Re: 7610 47th Avenue NE – Parr Lumber Expansion (PA22-026)

Thank you for your submittal of the above referenced project. After first review, the Planning Division has the following comments:

RE: Parr Lumber, File# PA22-026
Business Expansion
7610 47th Ave NE & Parcel #30052100422800

COVER SHEET
PARR LUMBER
MARYSVILLE, WASHINGTON

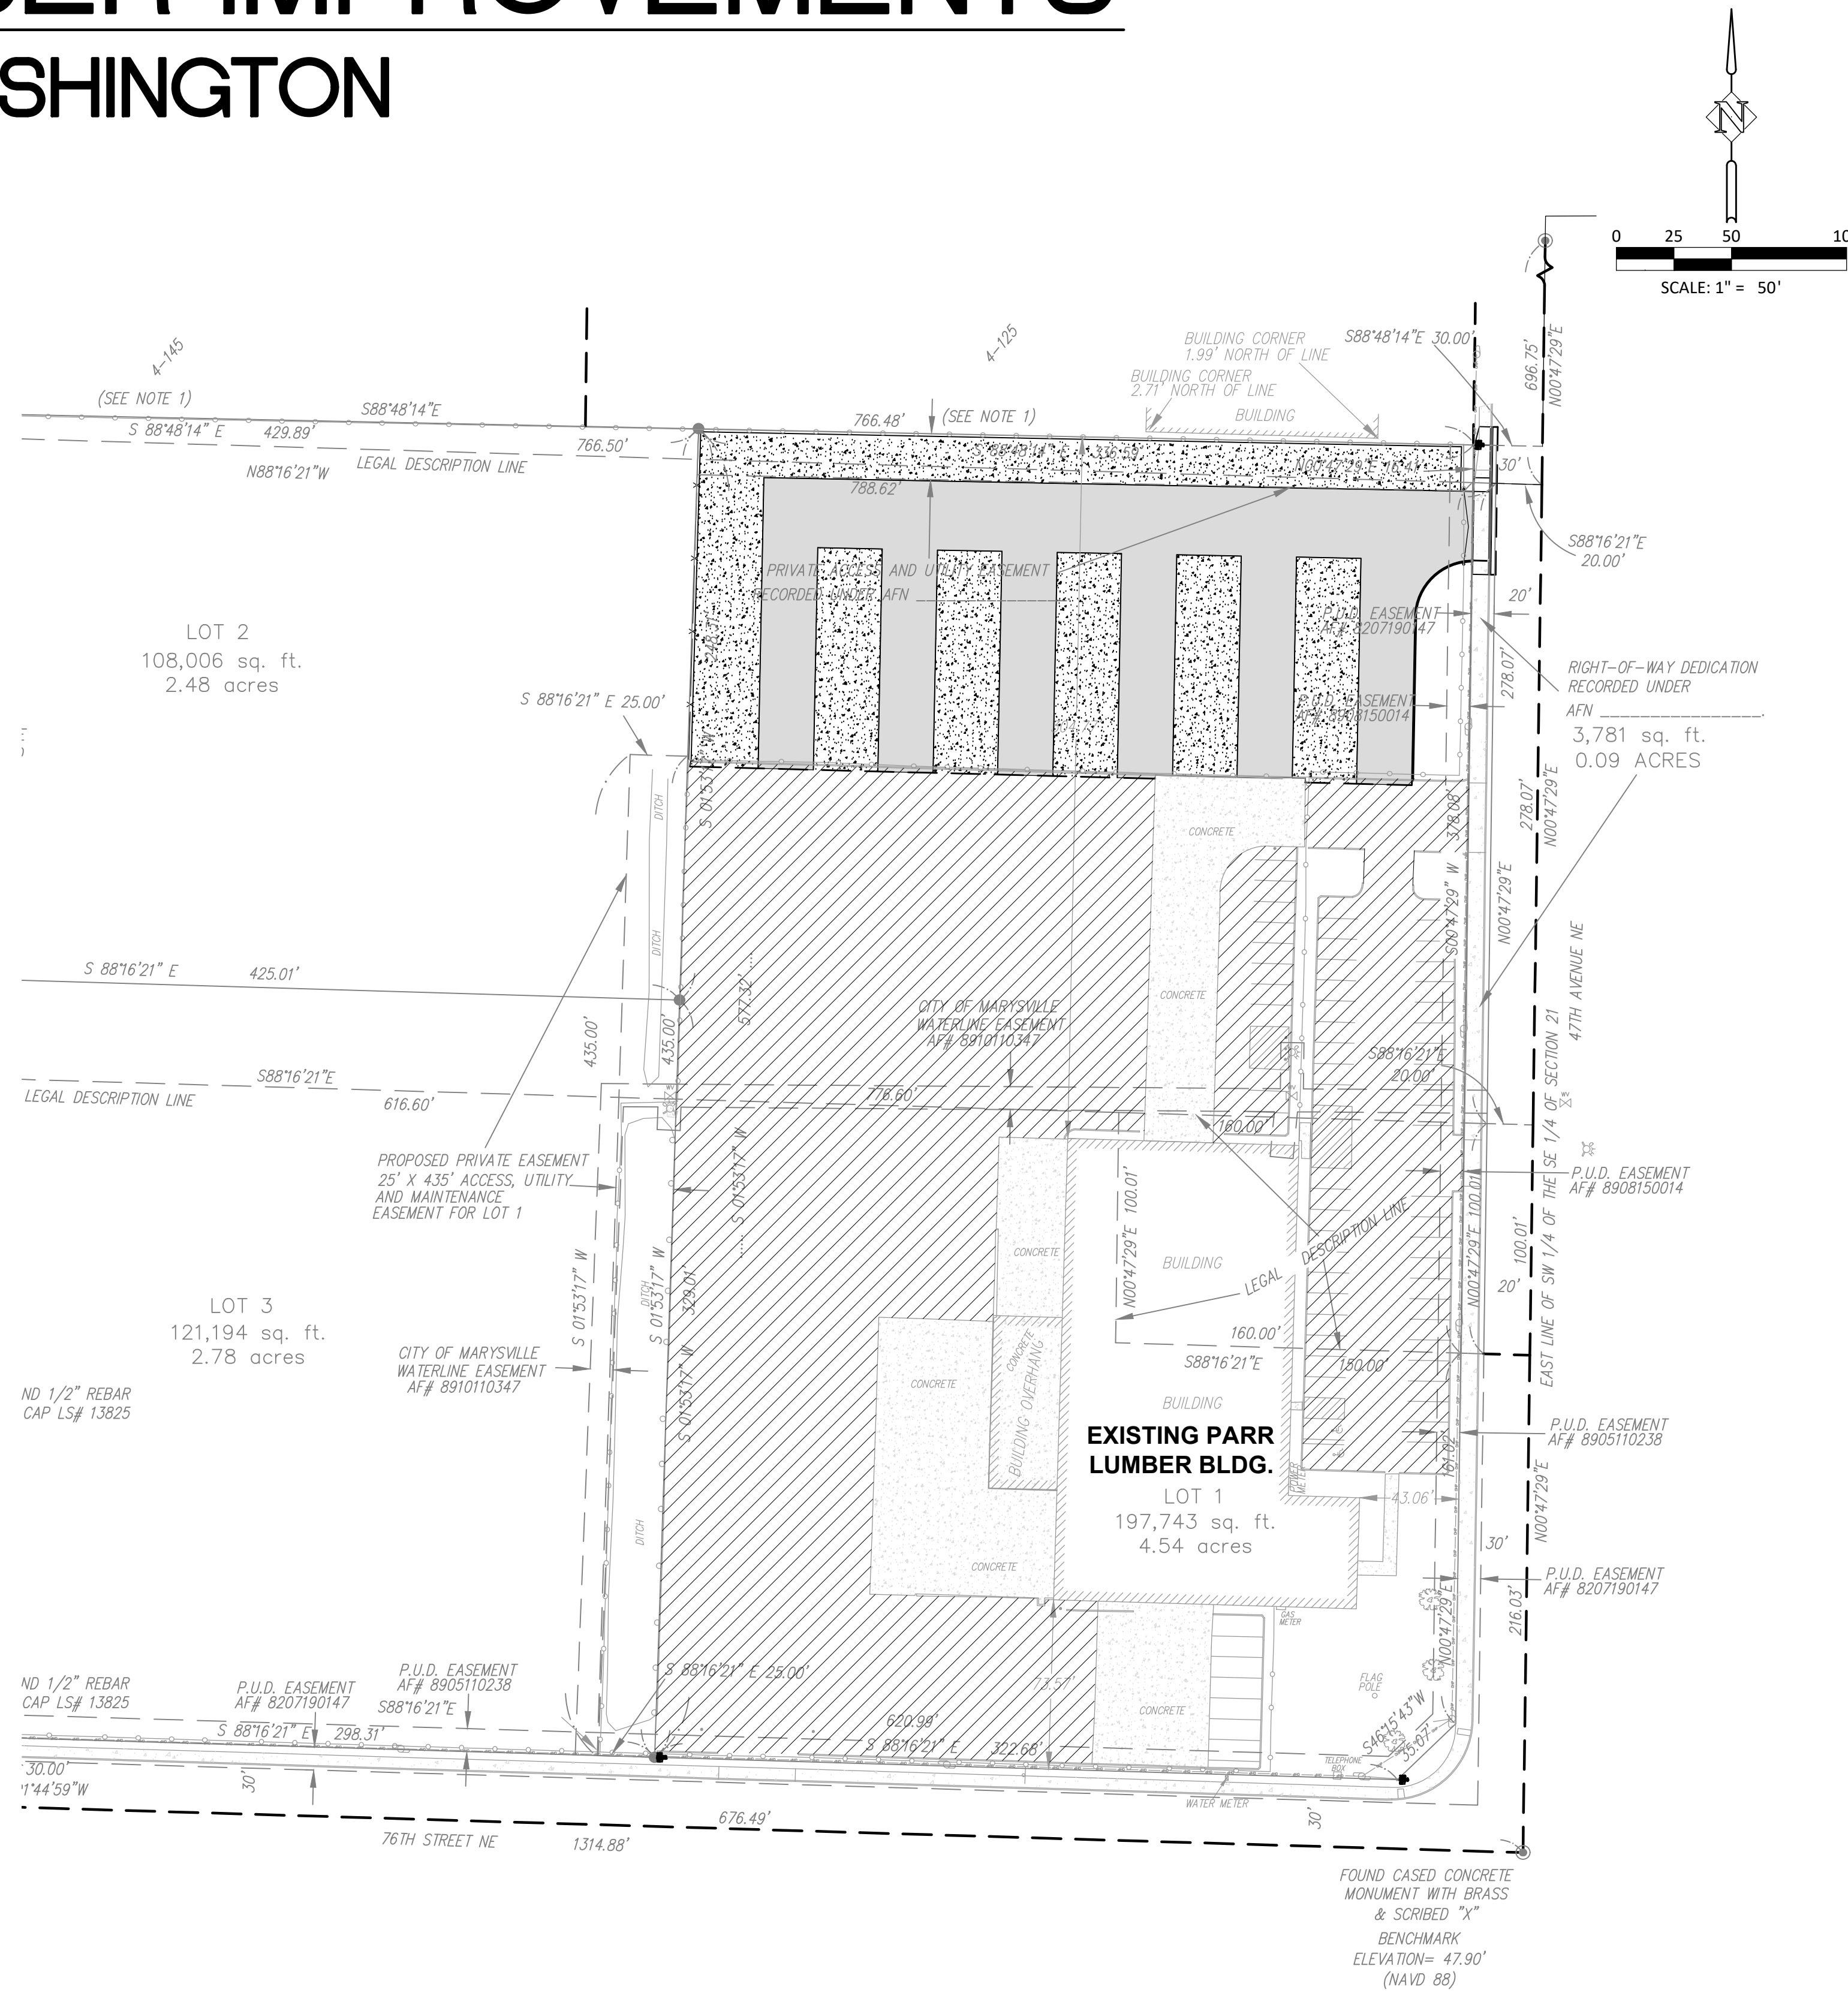
- 1) The total impervious surface for lots within the General Commercial (GC) zone shall not exceed 85%. Please provide the total existing and proposed impervious surface amounts in order to verify compliance.

- 2) Please add the appropriate AFN for the Private Access and Utility Easement on the northern property boundary (201109150315).
- 3) Please see memo from Shane Whitney regarding the proposed access and stormwater requirements.

SHEET NO.
C2.1
JOB NO. PAR-43

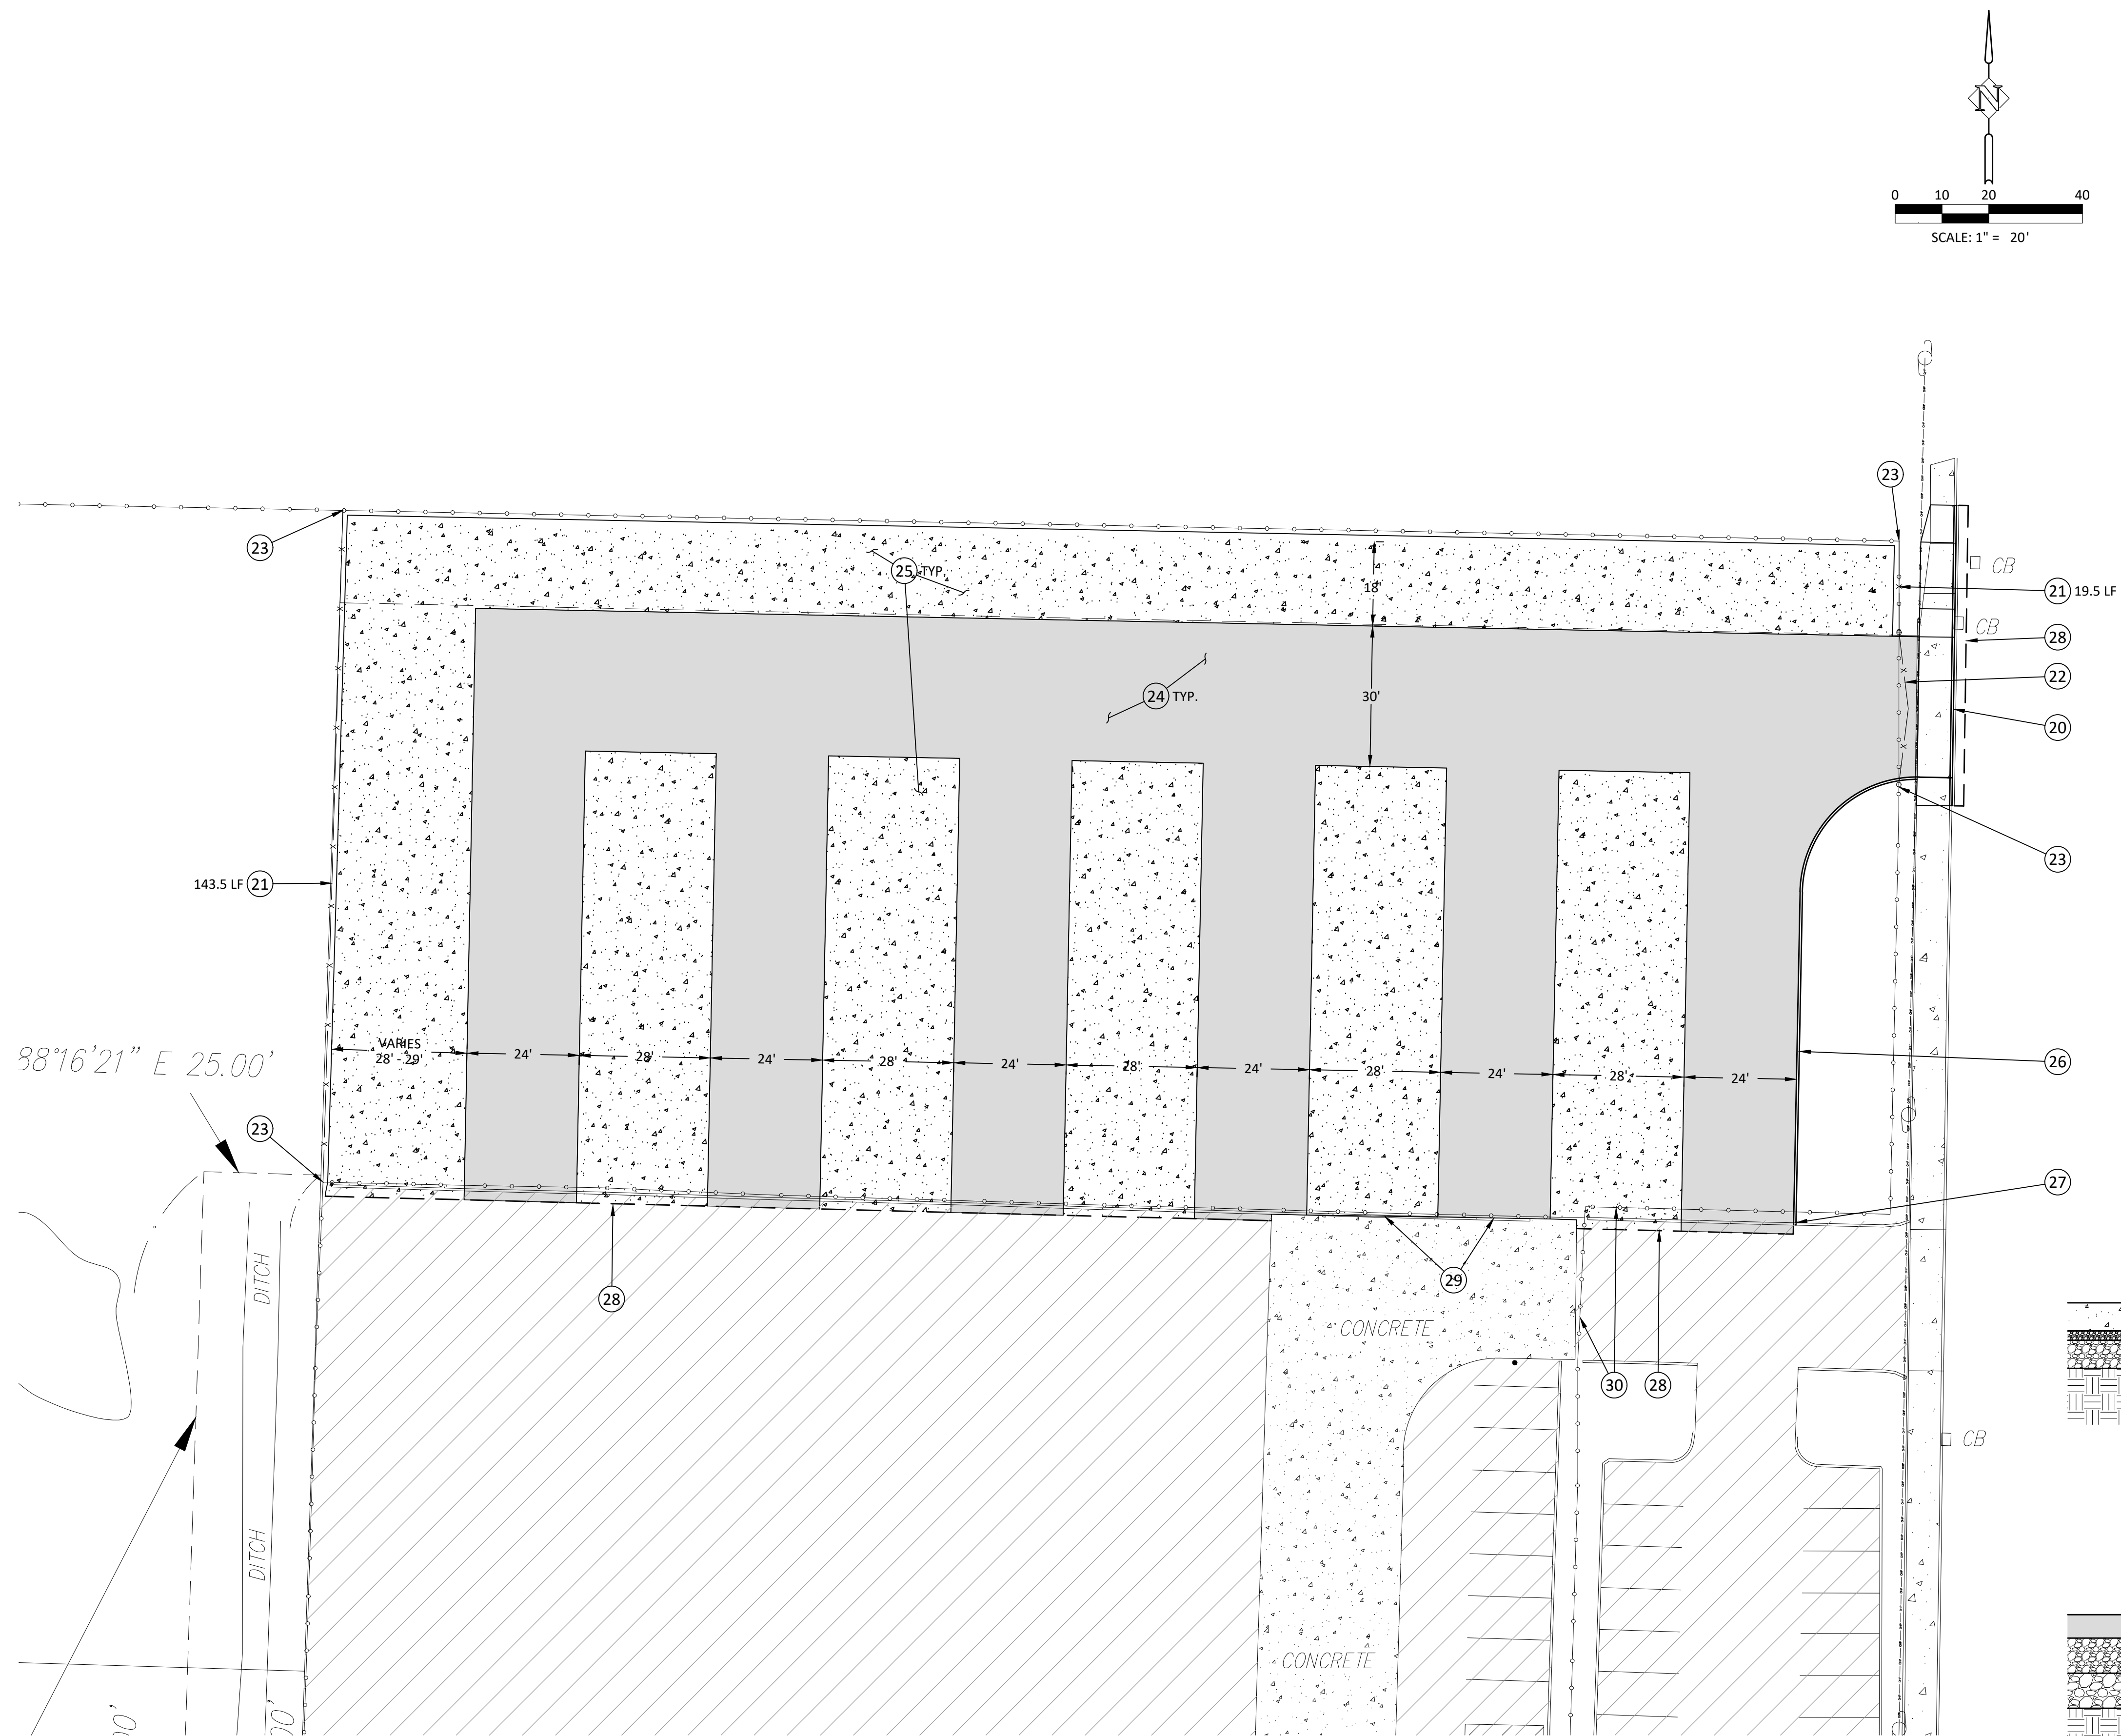
- A minimum 5-foot wide, 'Type L1' landscape buffer. Screening shall be provided on the west, north, and east (where possible) property lines adjacent to the new storage area (see green areas below).

- 5) All perimeter and interior landscaped areas must have cast in place or extruded protective curbs along the edges. Curbs separating landscaped areas from parking areas may allow storm water runoff to pass through them. Tire stops, bollards or other protective barriers may be used at the front ends of parking spaces. Curbs may be perforated or have gaps or breaks. Trees must have adequate protection from car doors as well as car bumpers.

- b. It does not appear that additional right-of-way is required for 47th Ave. NE.
5. **Access:**
 - a. The project must adhere to the arterial access standards, section 3-301 of the EDDS. Projects may have 1 access for every 500 feet of frontage. The parcel has

in excess of 500 feet of frontage on 47th Ave, but less than 1000. As such the proposed additional access is not specifically allowed. Should the applicant choose to want to add an access at the north end of the project, an engineering variance will be necessary.
